The Homestead
Chapel Lane
Bodicote
OX15 4DB

We are writing in connection with planning application no23/00088/F. This planning application is a revised version of planning application No 19/02001/F, which we have already objected to.

After our objections the building on Plot 2 of the original application was moved away from our boundary a significant distance and this was acceptable. But now an extension is proposed bringing it back in close proximity.

Client Mr and Mrs Alex Watson The Chaff Place High Street Bodicote Banbury Oxon OX15 4BS	Job Two proposed dwellings Alterations to previously approved plans – 19/02001/F Chaff Place High Street Bodicote	Scale 1:50 @ A1
		Date December 2022
		Dwg No 203

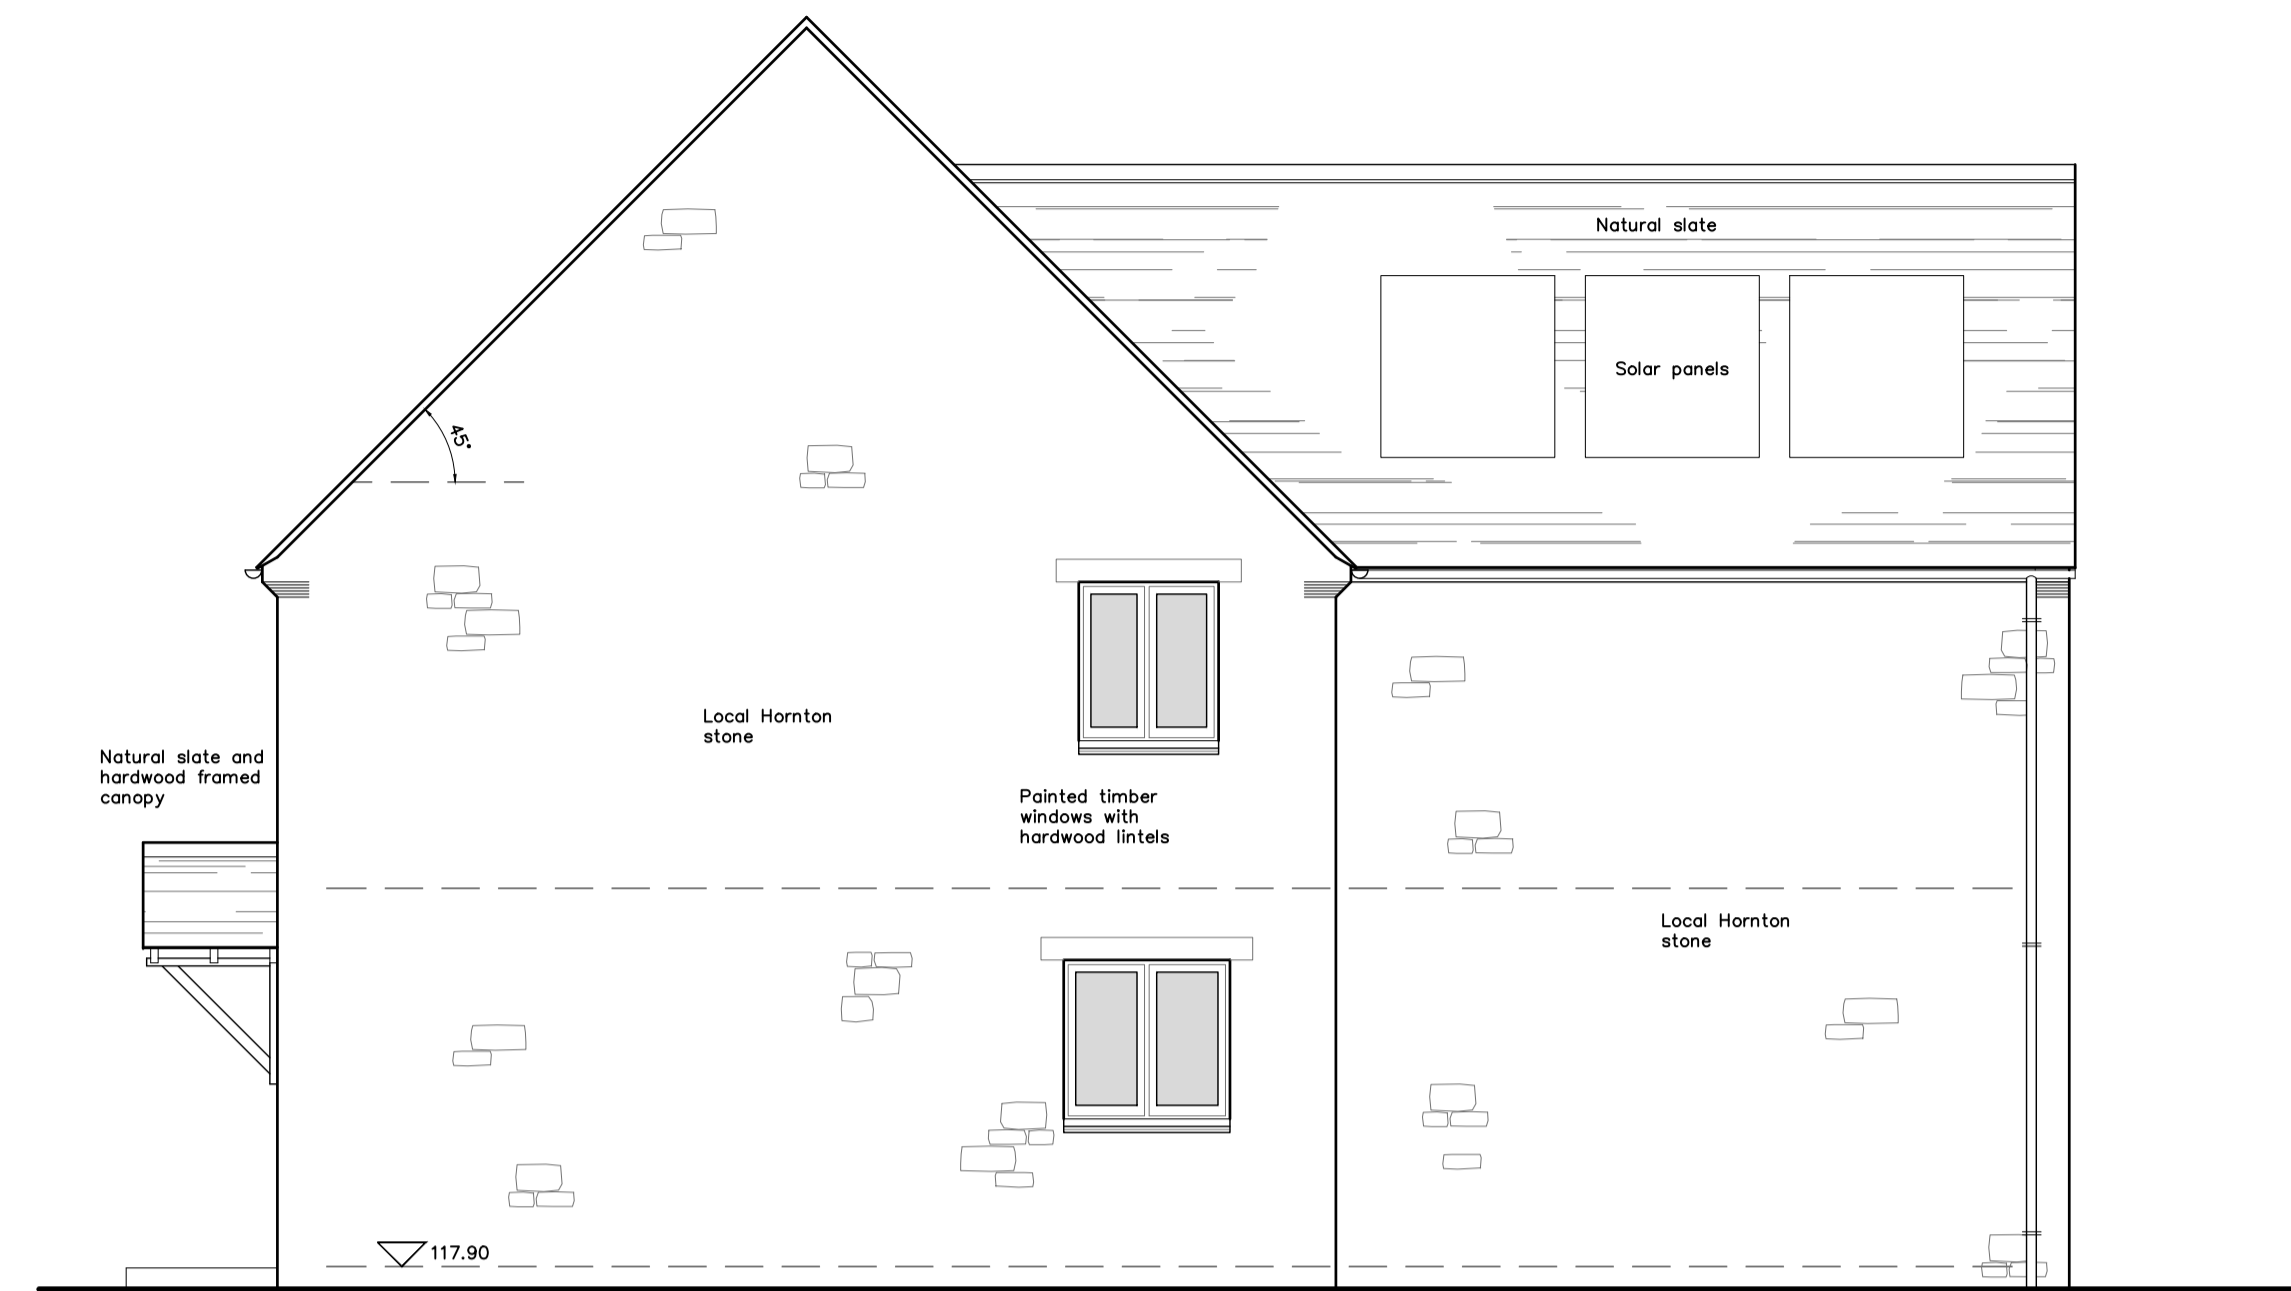
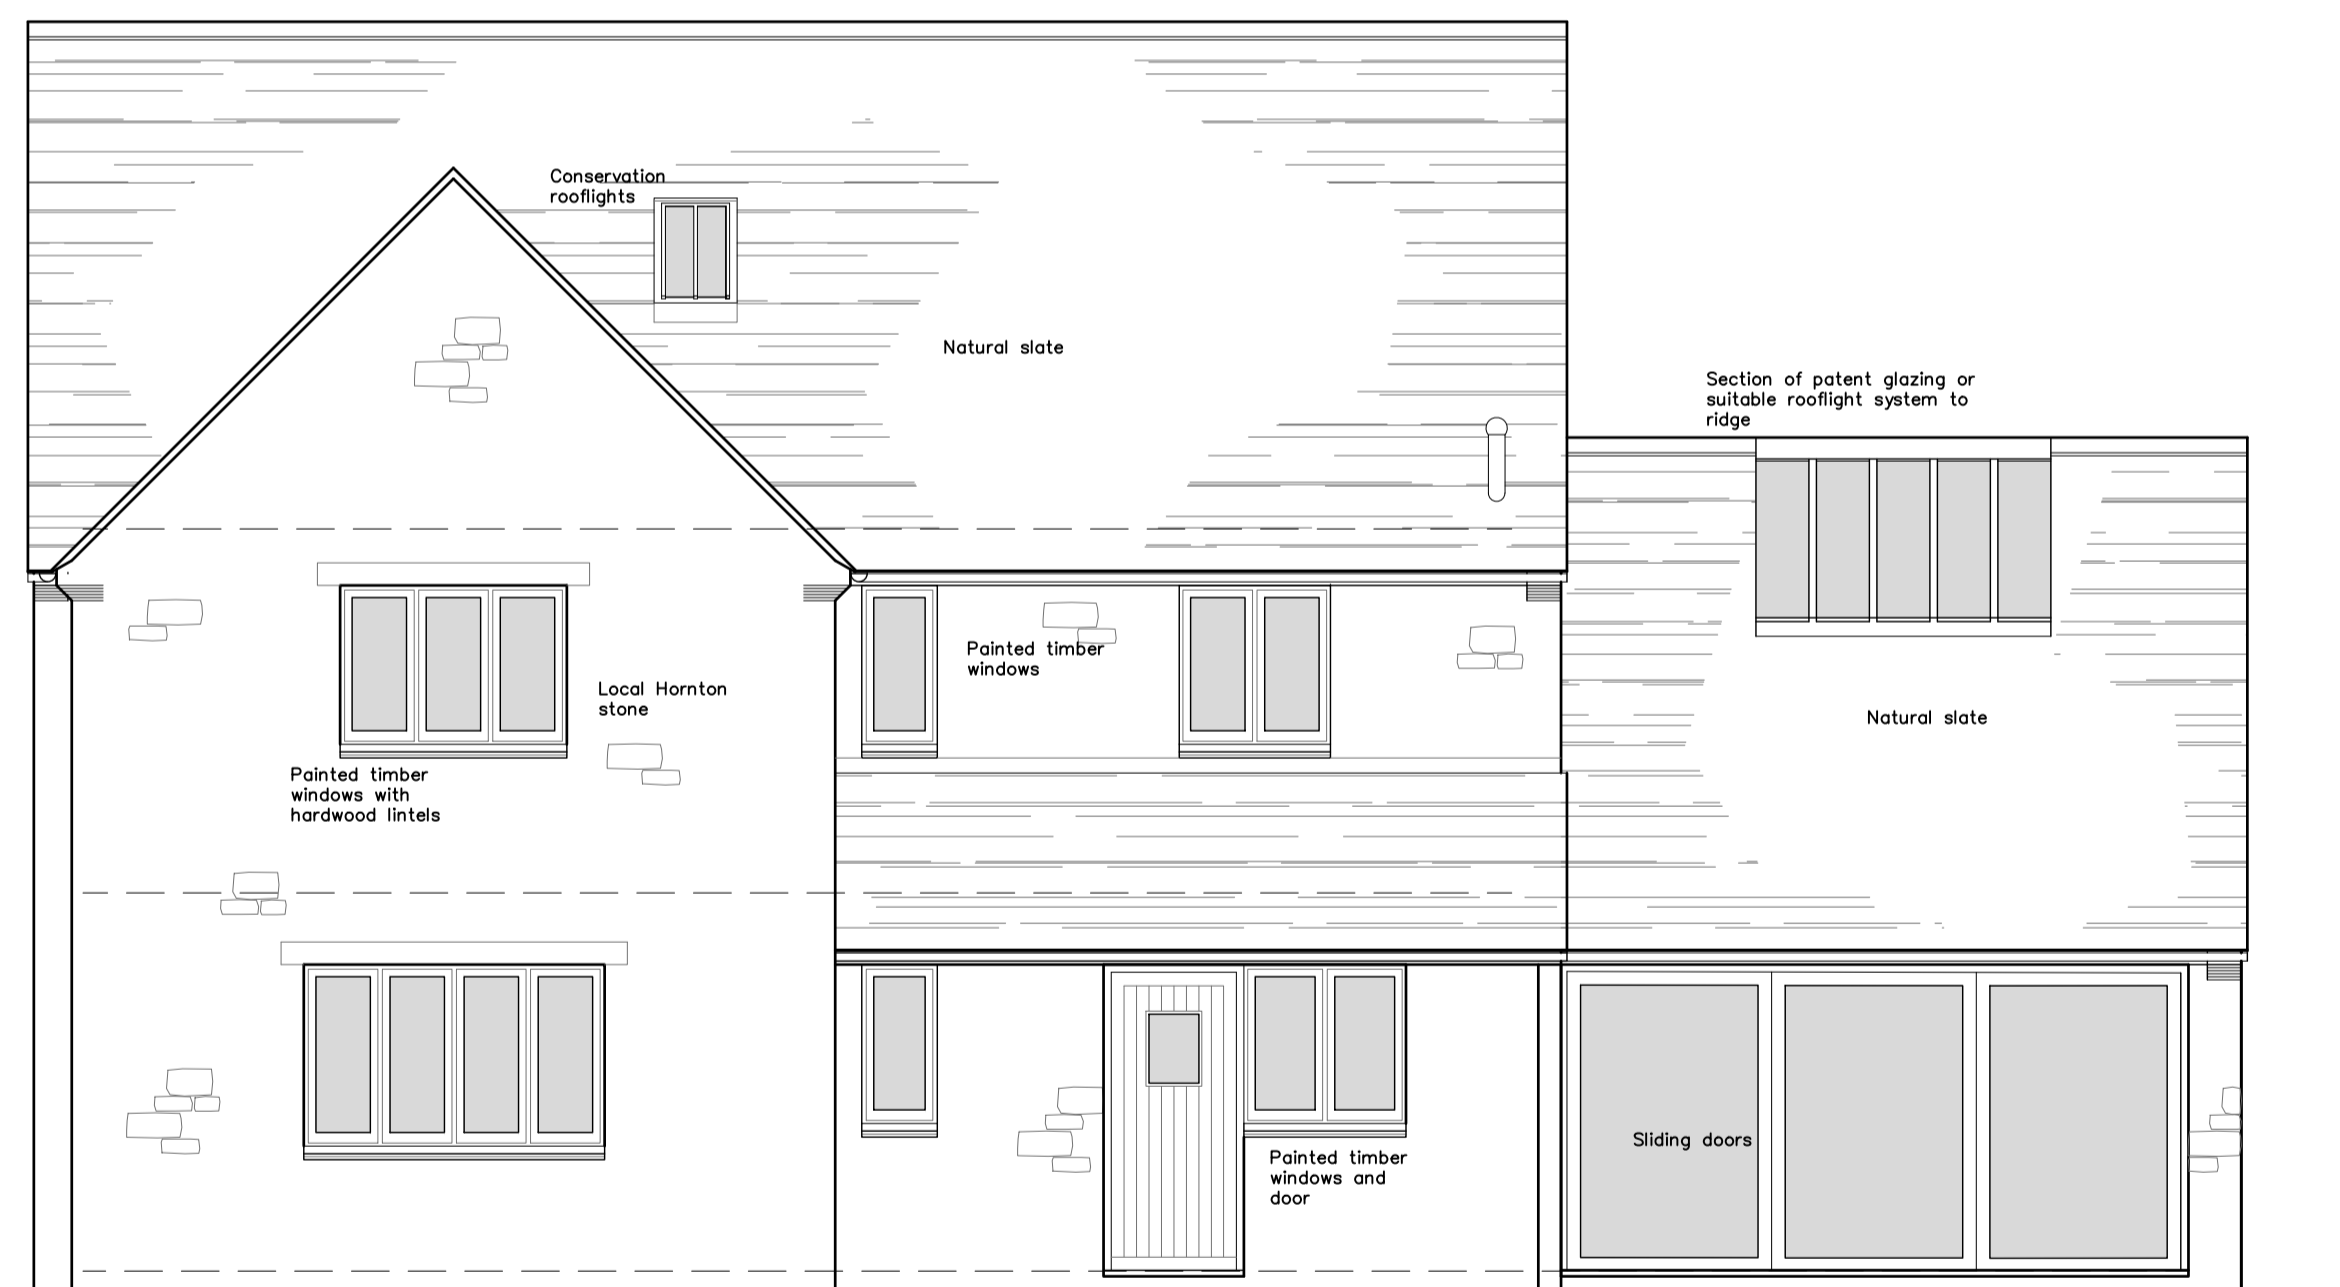
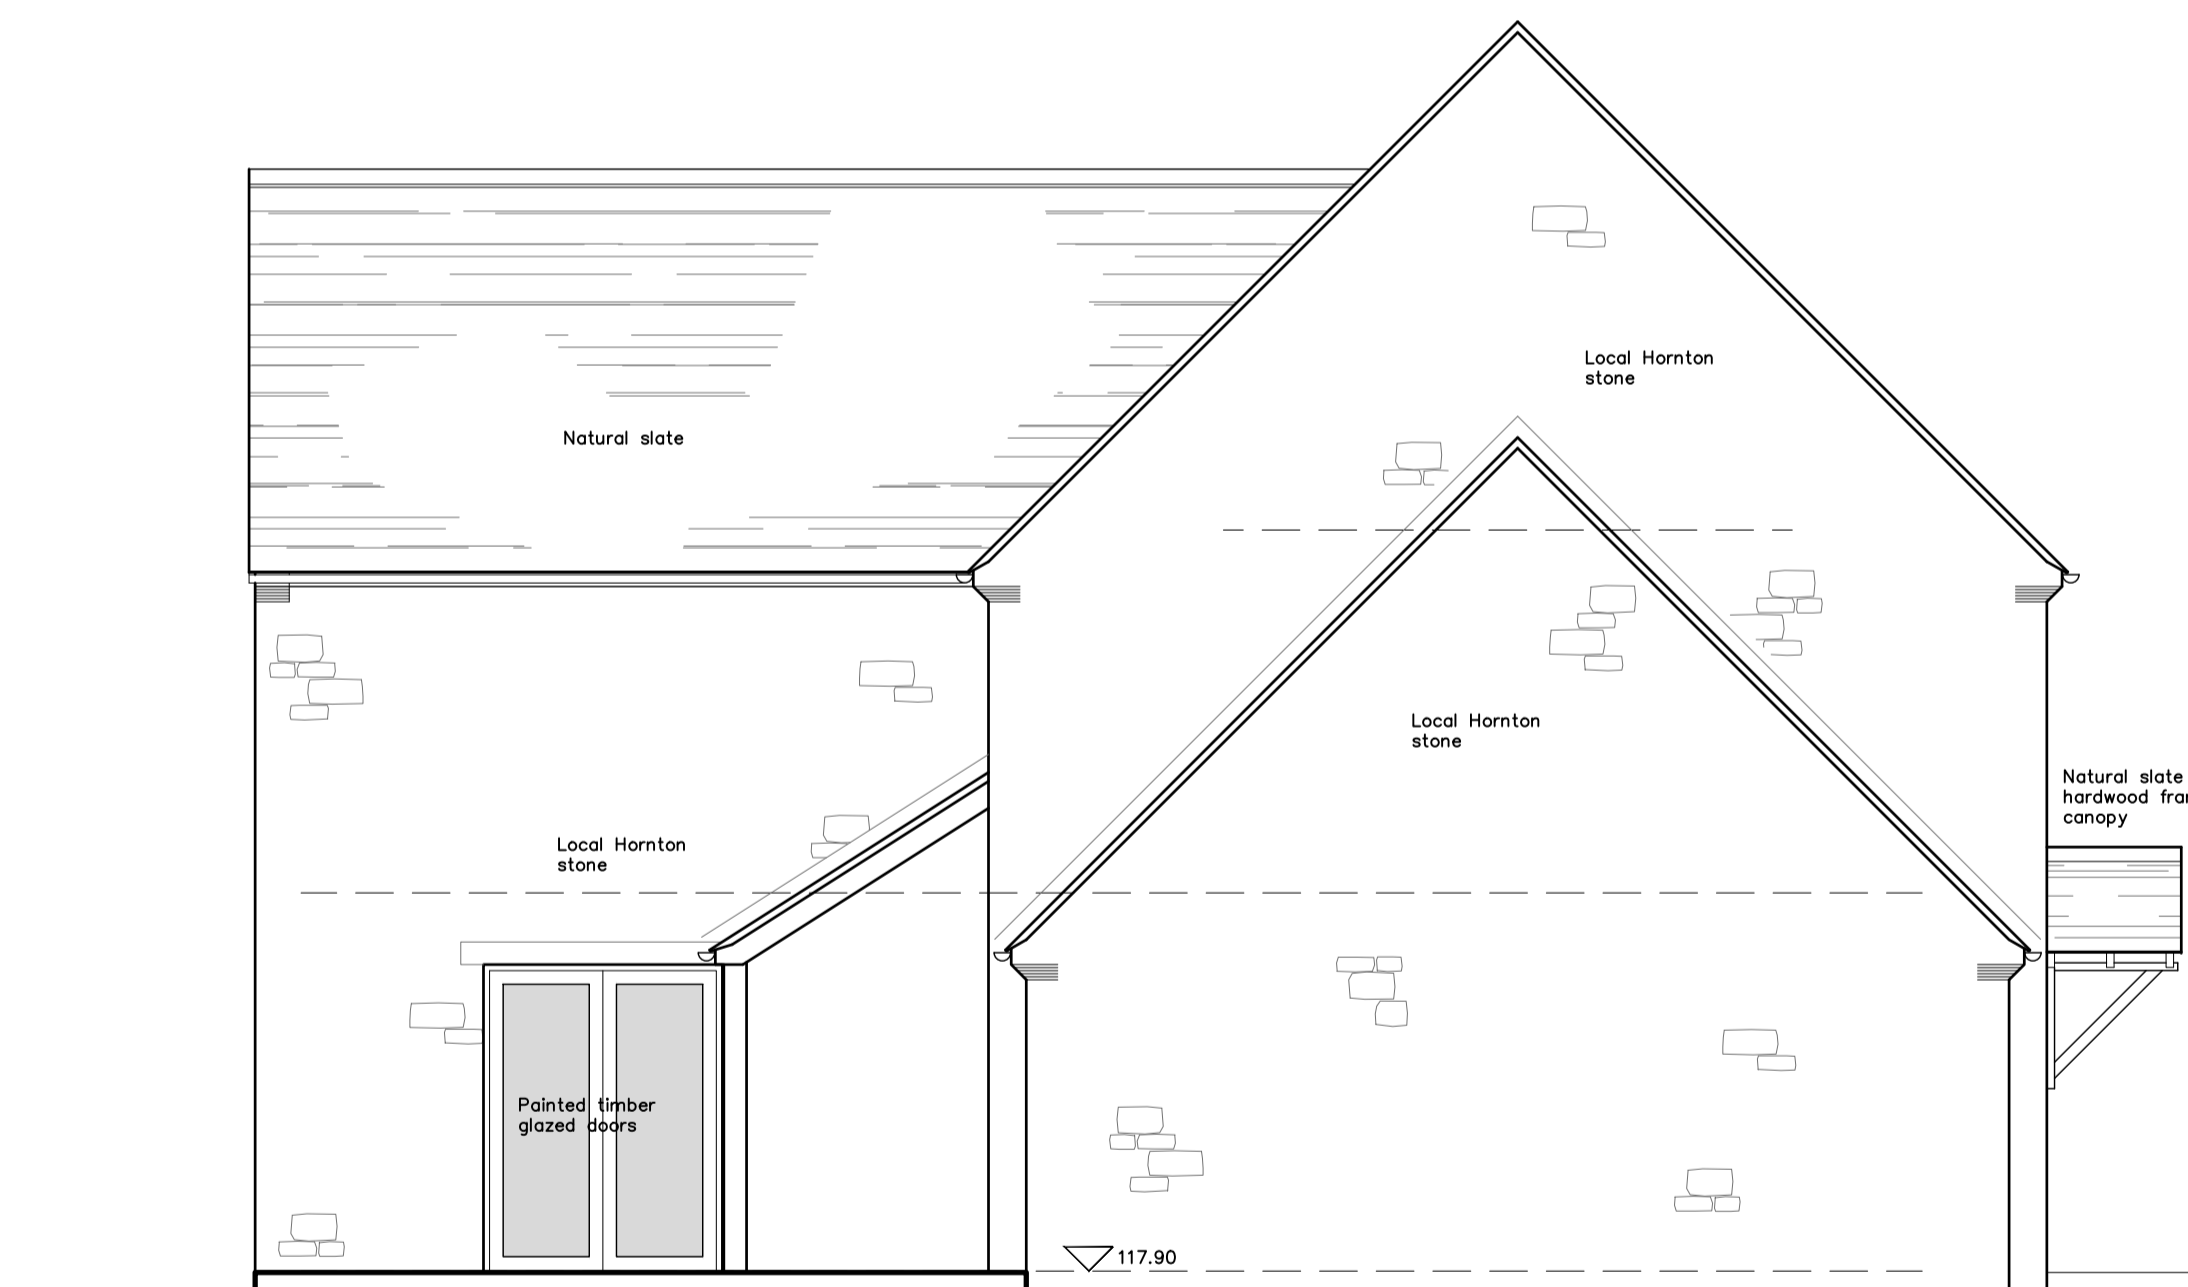
Although the proposed extension is single story to the eaves, to accommodate a second floor in the roof space it is going to be almost 6 meters high to the apex. With close proximity to the boundary wall it will still take a significant amount of light from the westward facing windows of our living room at the rear of the house and patio area. As pointed out in our original objection - points 3 & 4 dated 21/10/2019 - see attached letter. We believe this will contravene our right to light.
